Goodman
Level 17
60 Castlereagh Street
SYDNEY NSW 2000

3 February 2016

**Re: Orica Southlands Industrial Estate Project Approval 060191
Review of Turning Head Hydraulic Modelling Assessment**

(b) As-Con with Turning Head at RL~3.85m (Scenario 1) - As Constructed

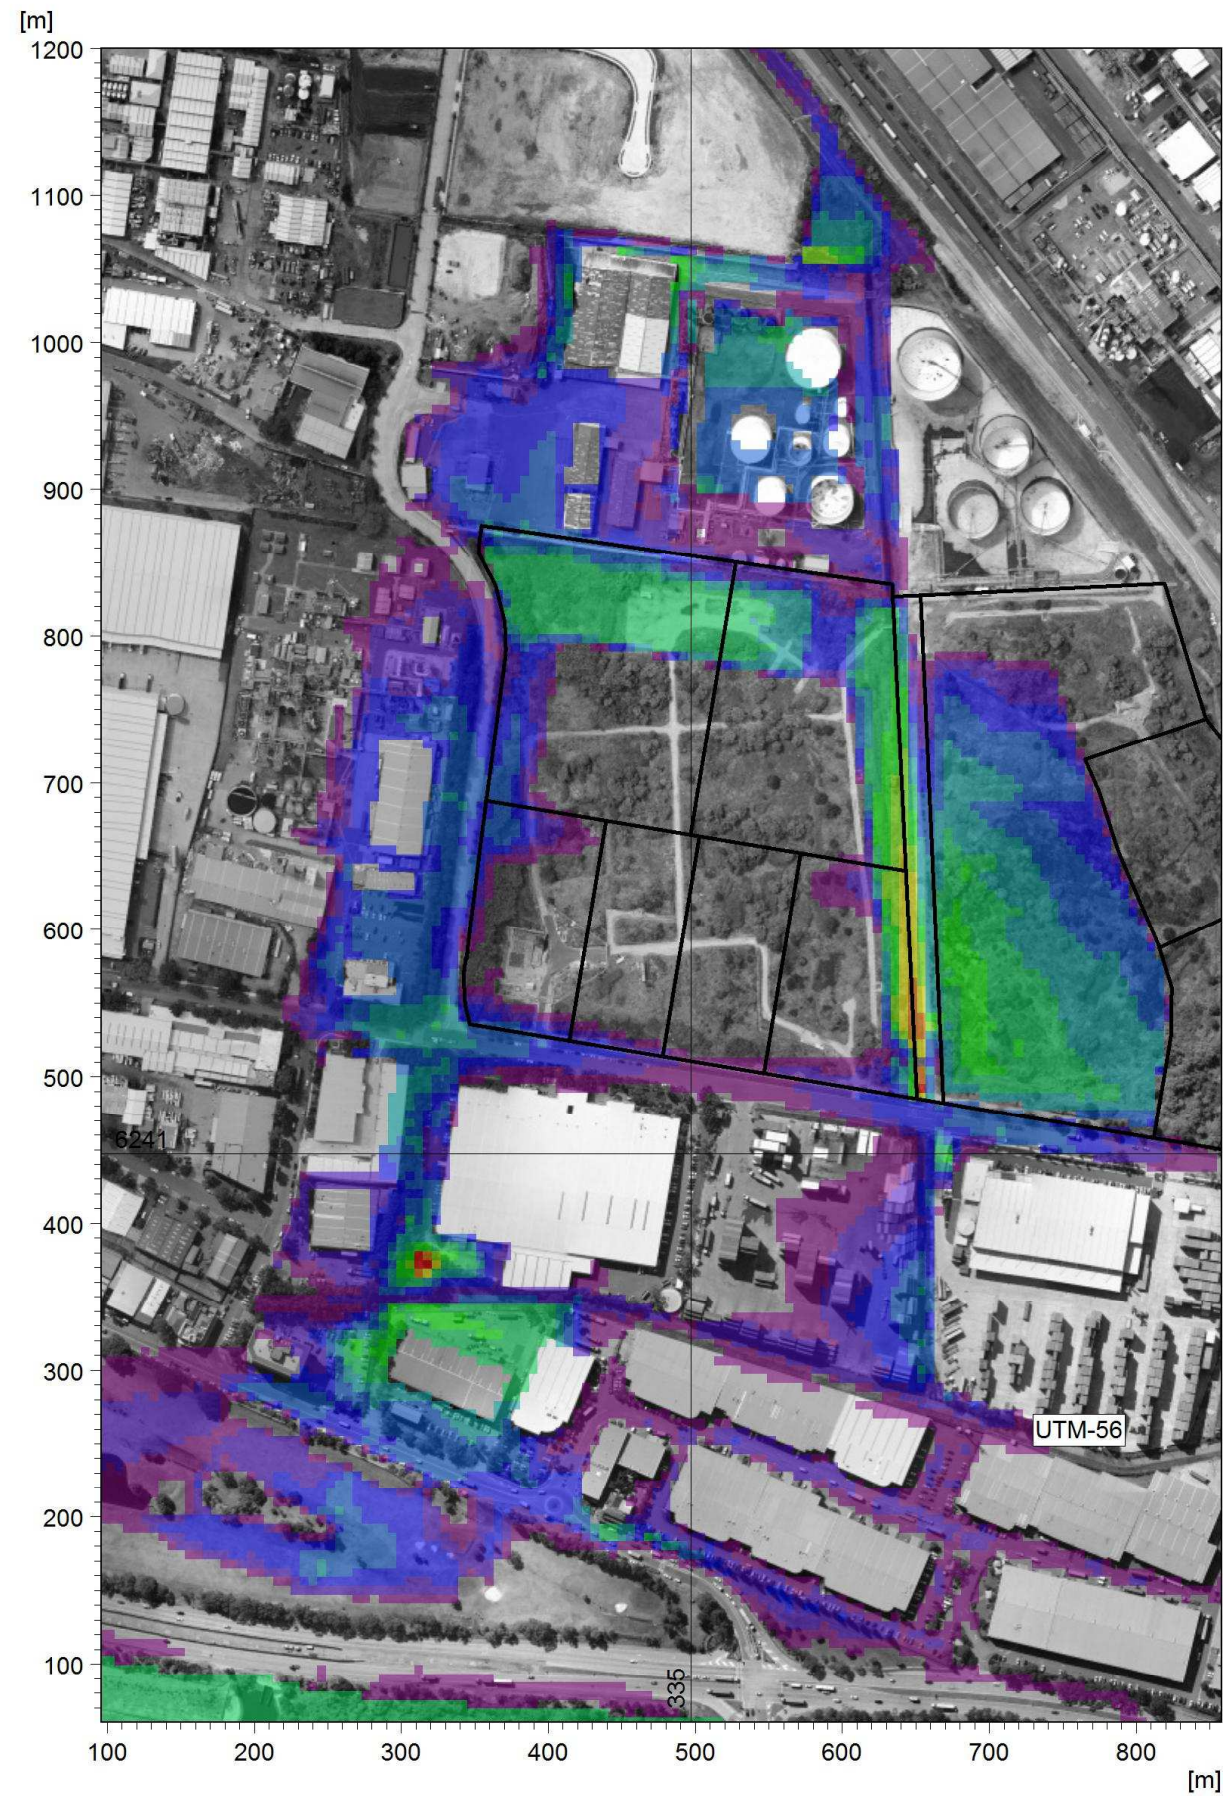
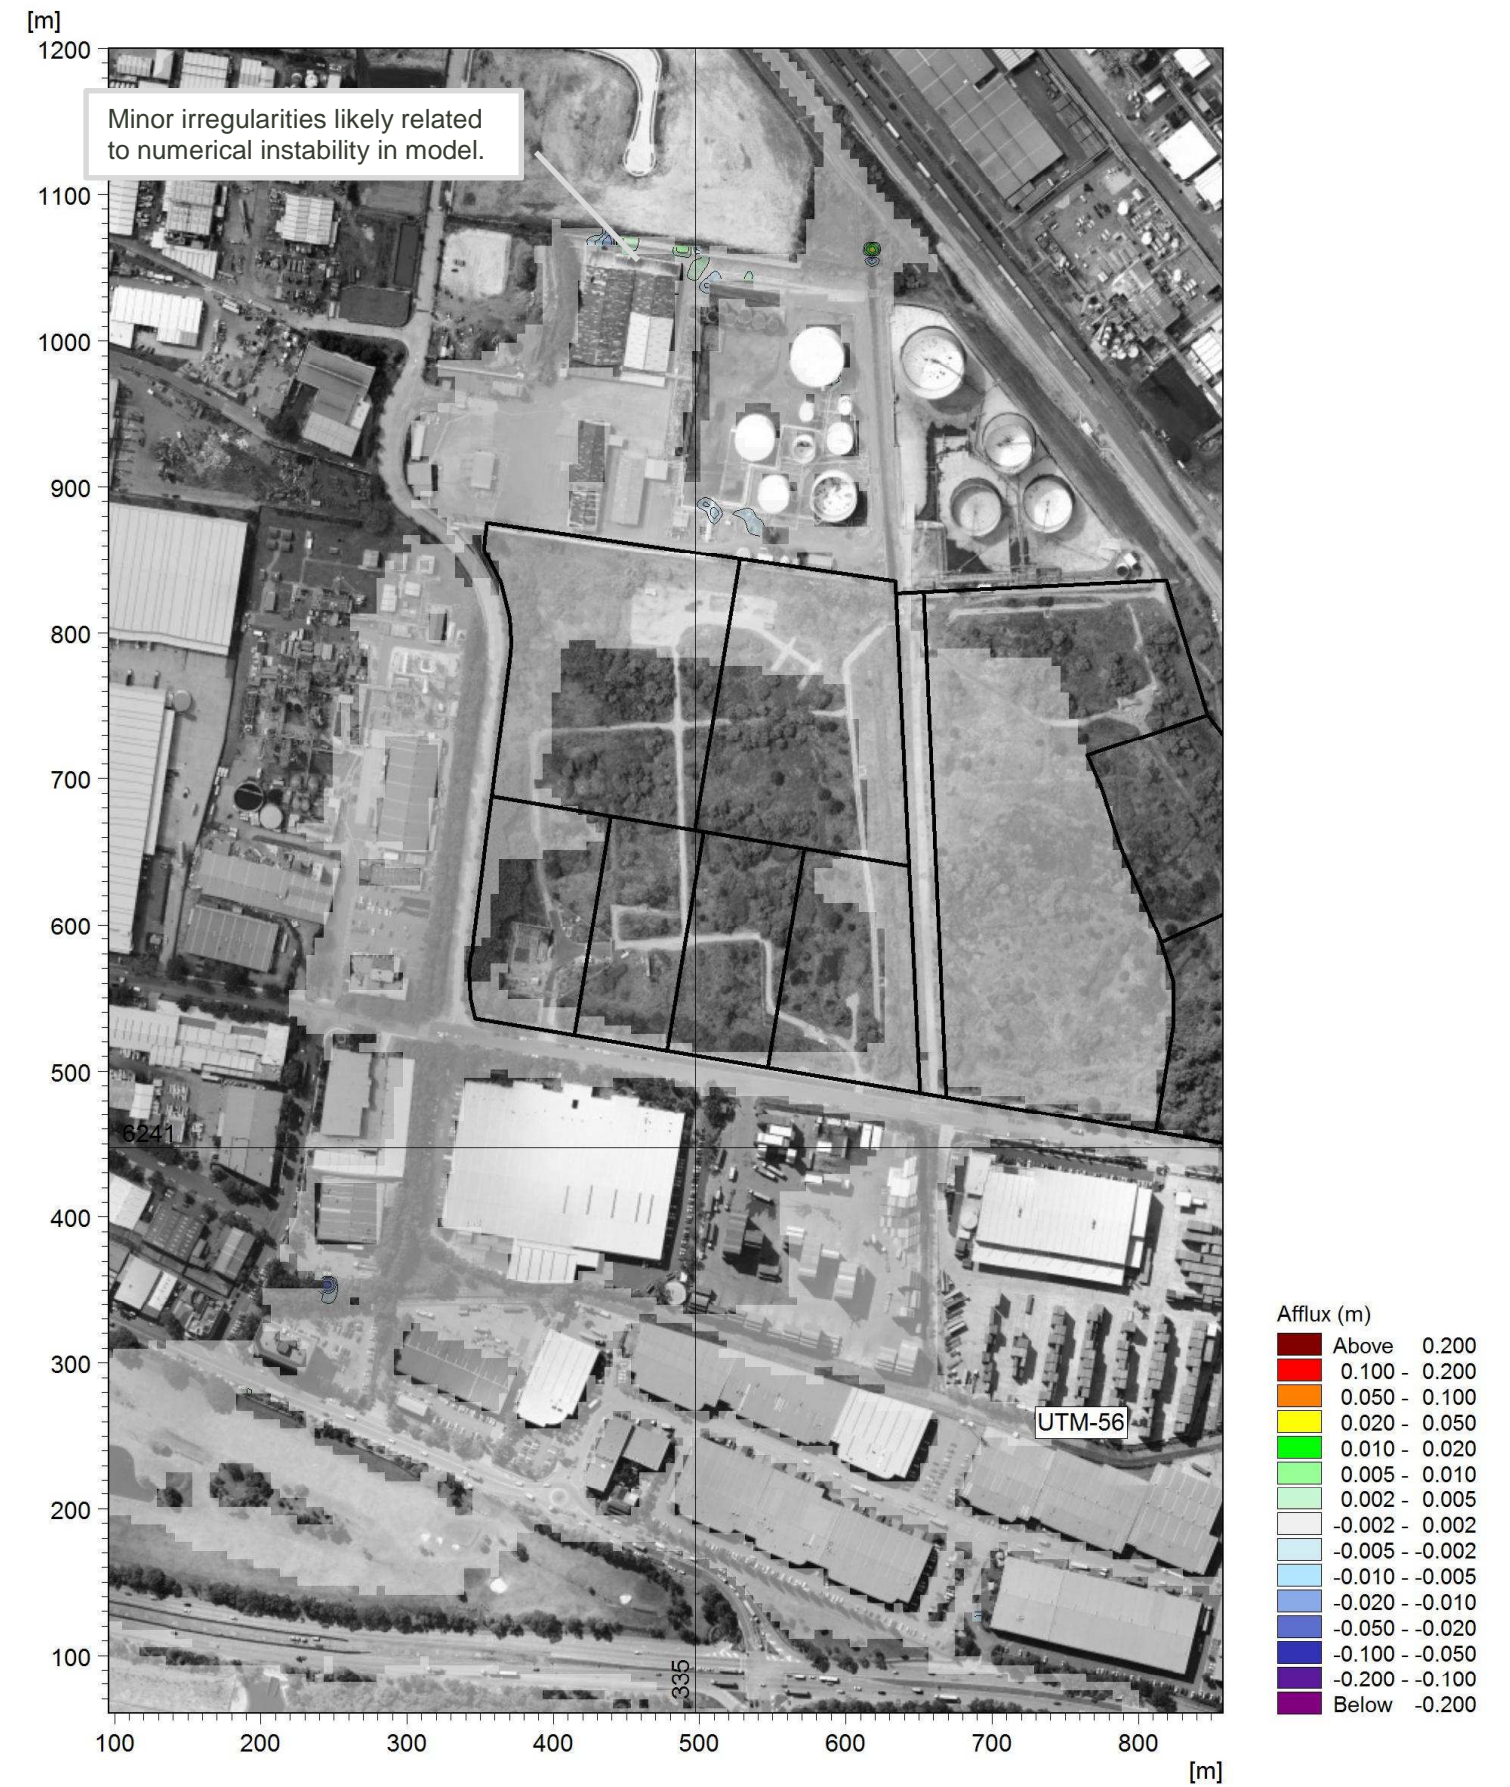
The turning head is below the 1% AEP flood level however the proposed height is acceptable for the following reasons:

- raising the level will cause unacceptable increases in flood level;
- the probability of a coincident fire and flood is very rare;
- flood depth warning signs will be provided and the fire service can make an informed decision regarding access should they attend during a flood.

Yes, taking into account the above comments, the “as constructed plus turning head” flood impacts are no greater than the nominated design flood impacts and Schedule 3 Condition 10 has been satisfied. Field survey of the constructed turning head should be undertaken and provided to satisfy Condition 10 c).
